Application No: CM/26/21/A
Site Address: Bairds Farm Shop, Garden Centre Crookthorn Lane Climping BN17 5SN
Description of works: Installation of 4 x externally illuminated fascia signs

Thank you for your internet representation made on 28th July 2021 which has been recorded as an objection with the comments as follows:

OWPC38919

Proposed Front Elevation
Scale: 1:50

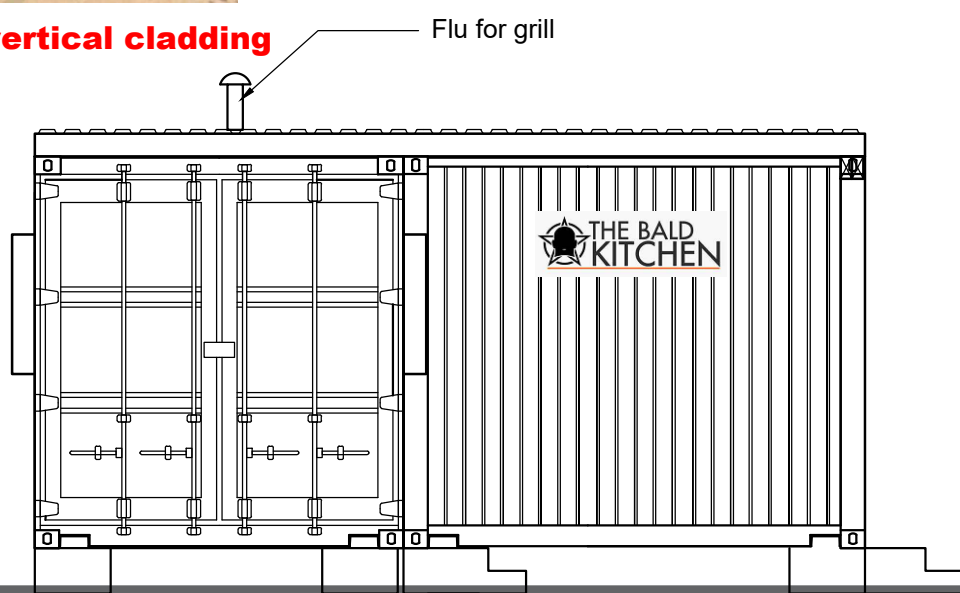
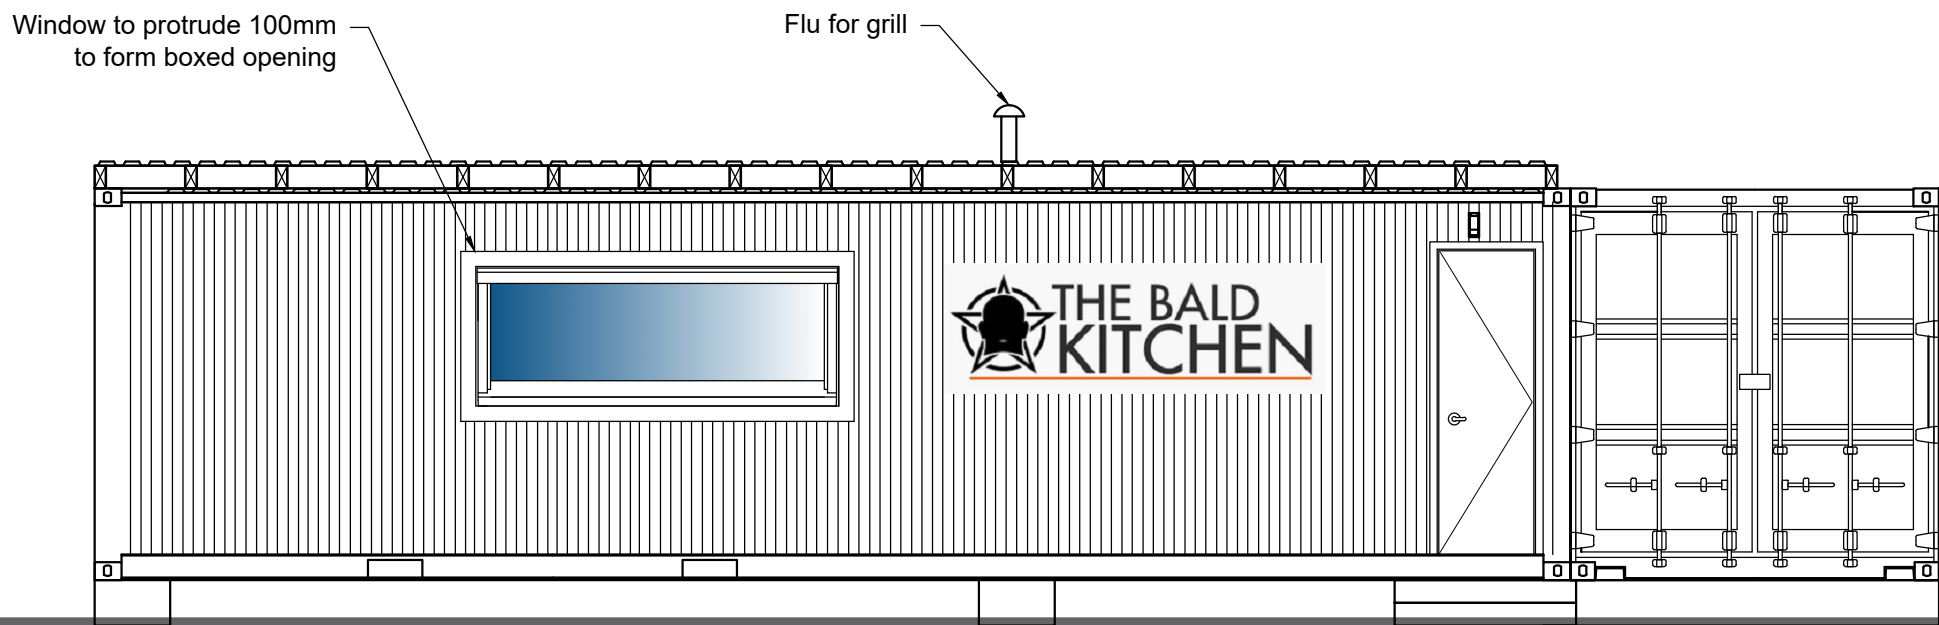
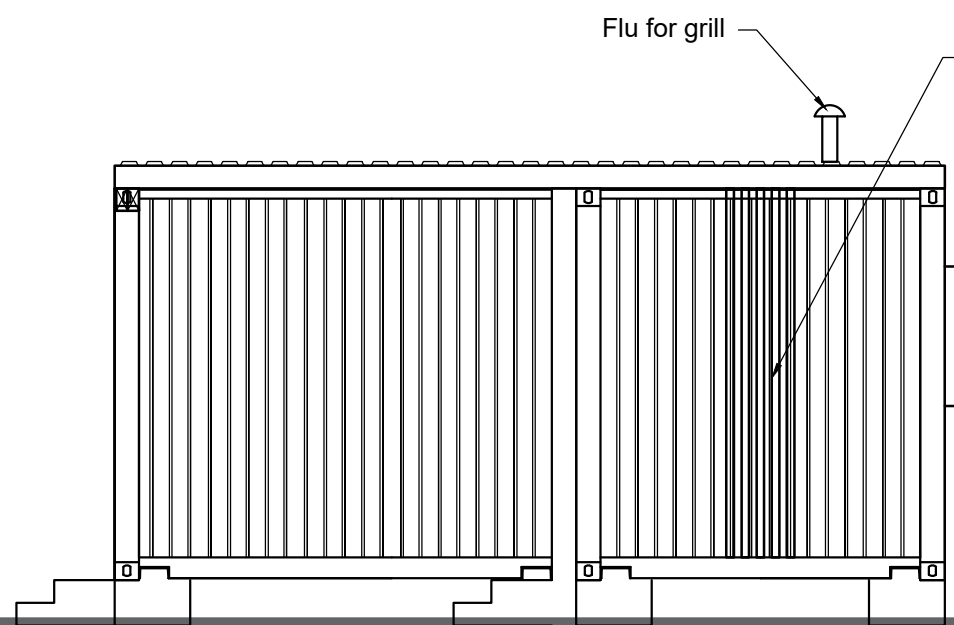
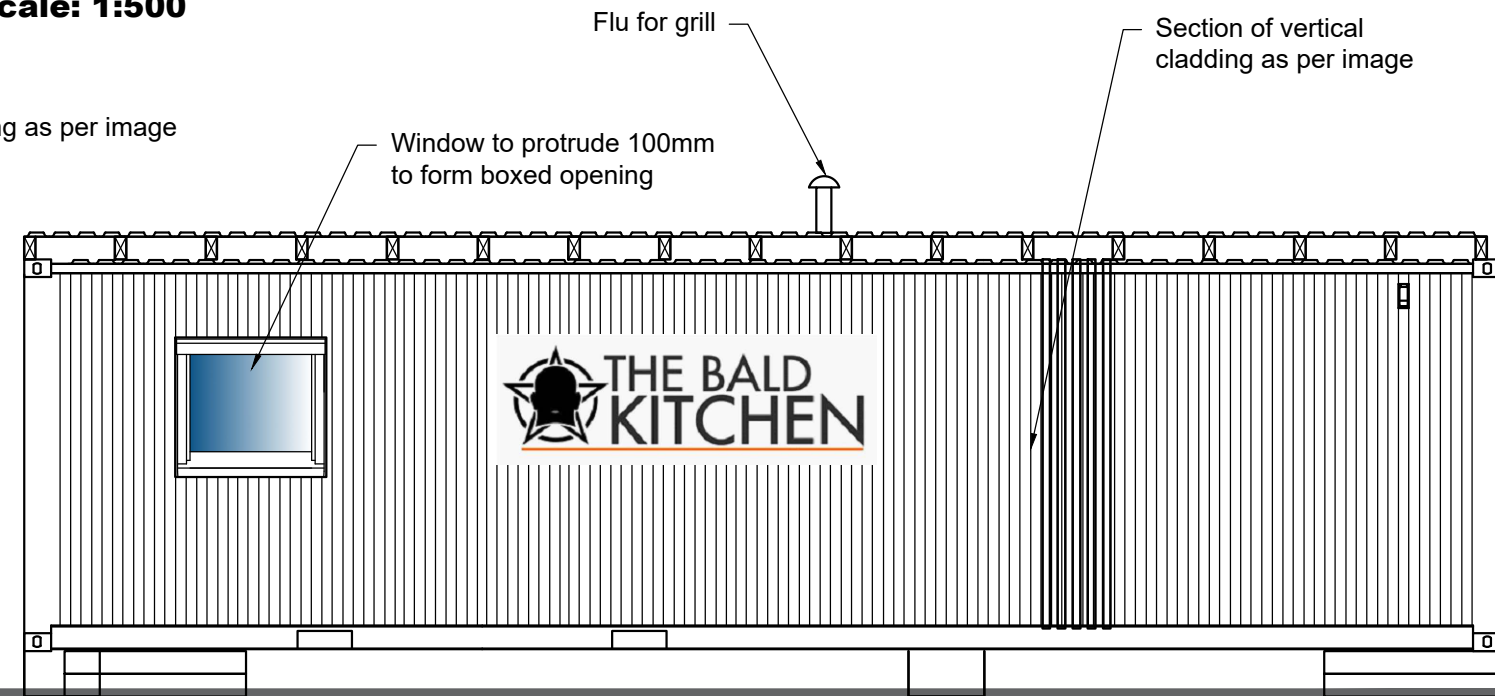
Clymping Parish Council strongly objects to this application on the basis that a proposal for illuminated fascia signs at this site is inappropriate illumination and totally out of keeping with the character of the area and will intrude on a rural area.

The proposal is contrary to policies CPN4 & CPN11 of the Clymping Neighbourhood Plan. The illuminated signs will impact on the amenities enjoyed by occupants of surrounding properties and does not integrate with the local built environment and landscape context as described in the Clymping Character Assessment.

Clymping Parish Council notes that the application does not contain any reference to brightness of the signs or the times of illumination. Should any such illumination ever be permitted, stricter controls on the strength of light and the hours need to be provided as part of the application. It should also be considered that as the site is within a rural area, such lighting could have an impact on wildlife.

Furthermore, in terms of highway safety, the proposal of four illuminated signs could confuse and distract drivers on A259.
